Stage 1 Road Safety Audit

Residential Development, Rosshill, Galway
On behalf of Kegata Ltd

December 2019

Drawing file: Tobin / 10690-2014_Rev B - Proposed Pedestrian, Cycle & Public Transport Infrastrcture.pdf

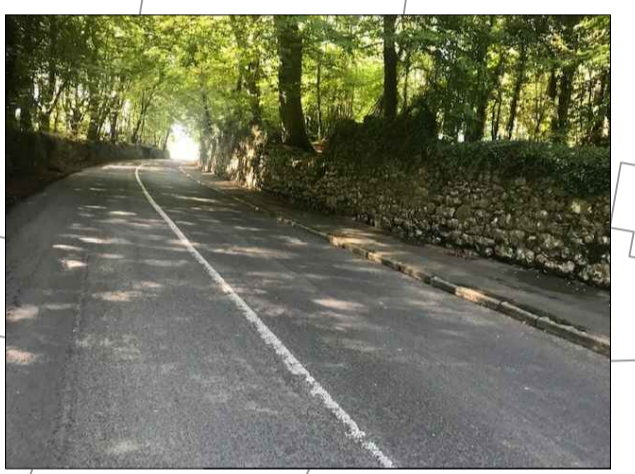
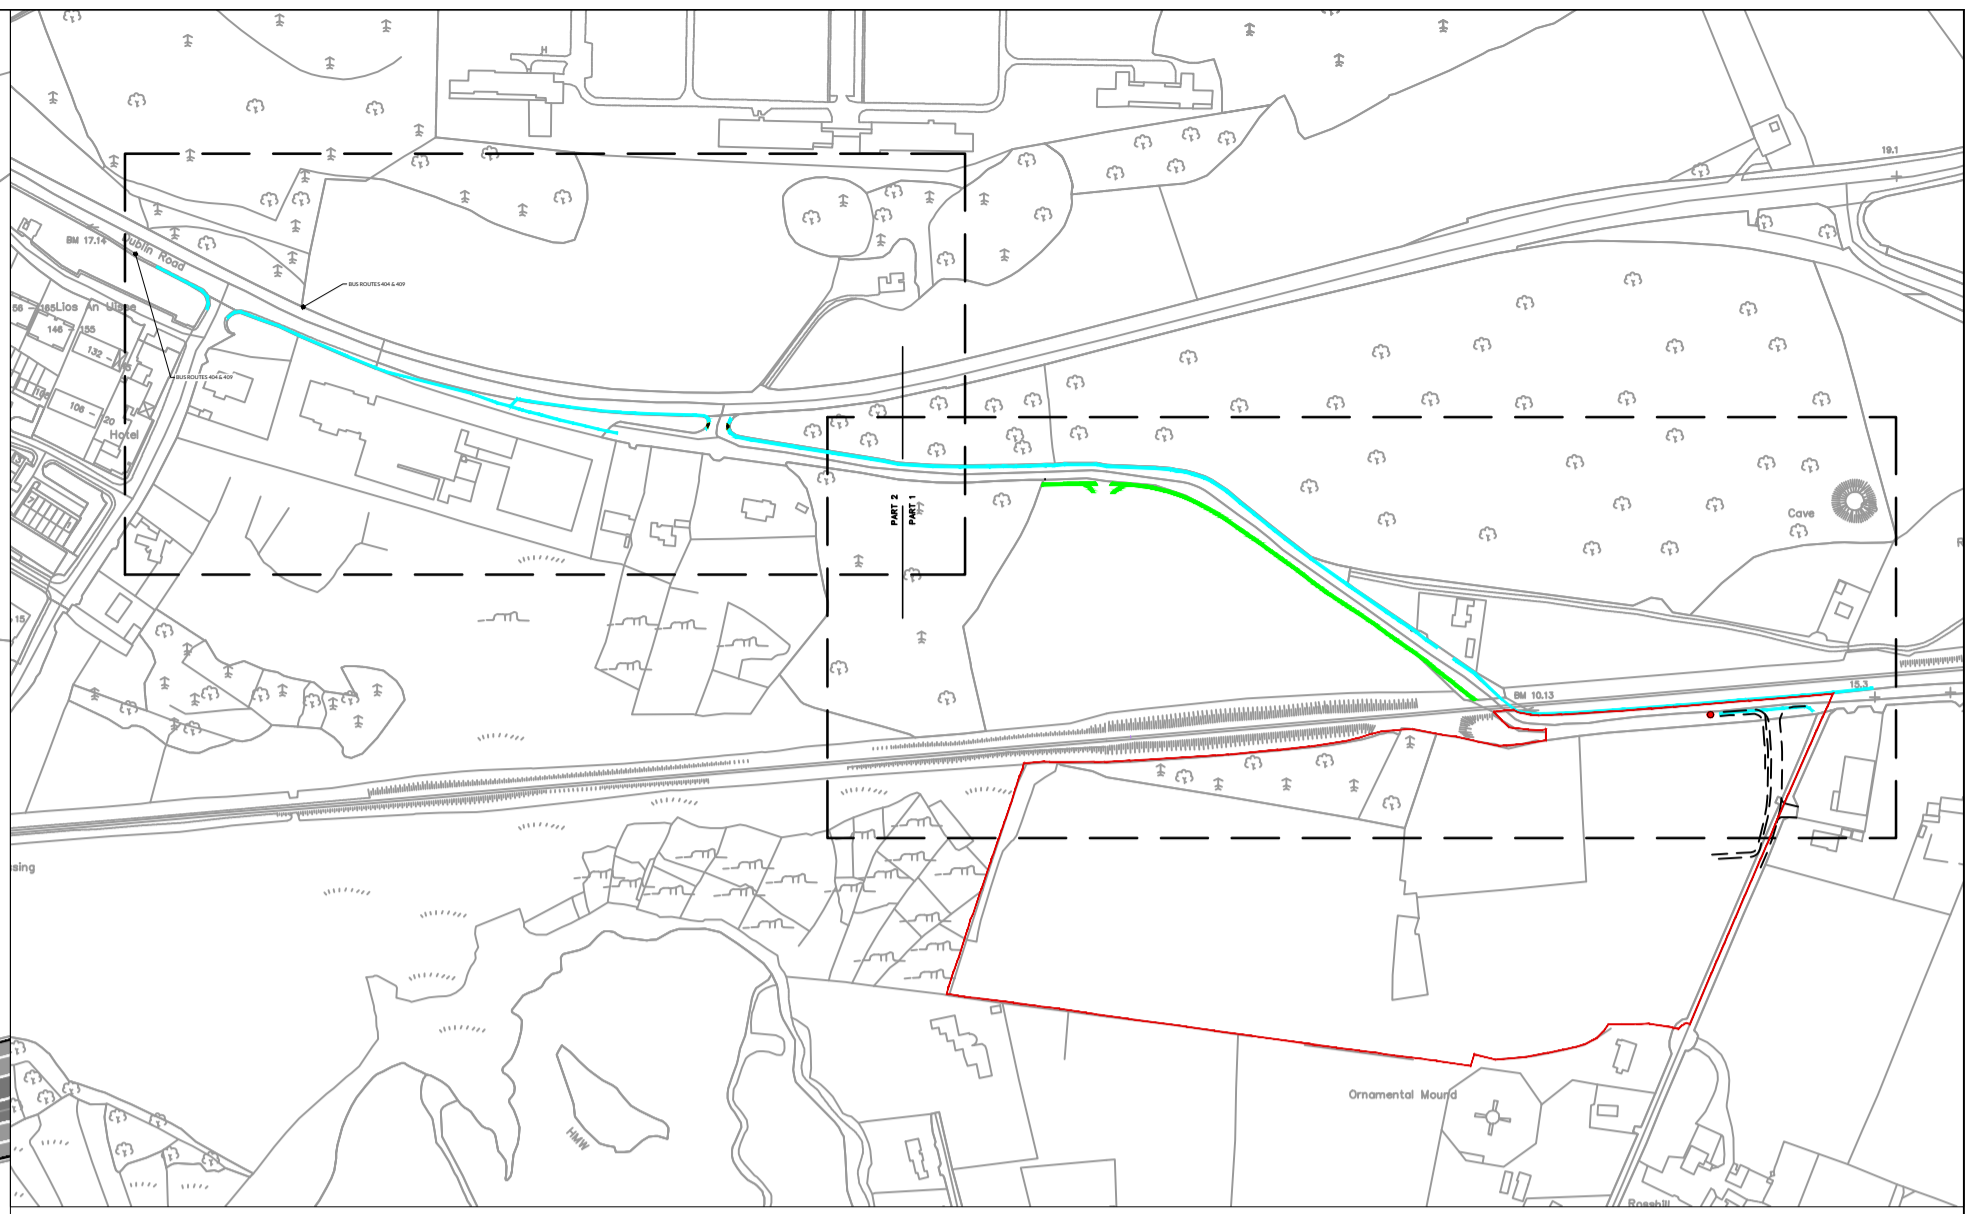
2.2.1 Old Dublin Road – Rosshill Road: Pedestrian Access to the Development

Problem: Neither the Old Dublin Road or the Rosshill Road have suitable pedestrian or cycle facilities. The proposed development is likely to generate substantial pedestrian and cyclist numbers.

2.2.2 Pedestrian Connectivity

Problem: There are no safe crossing points to the existing footway.

Recommendation: Provision of suitable safe crossing facility to existing footway or provision of continuous footways

2.2.1	Y	Y	Repair works to be carried out to ex footpaths as identified on accompanying drawings 10690-2013 & 2014	
2.2.2	Y	Y	New crossing points to be provided as identified on drawings 10690-2013 & 2014
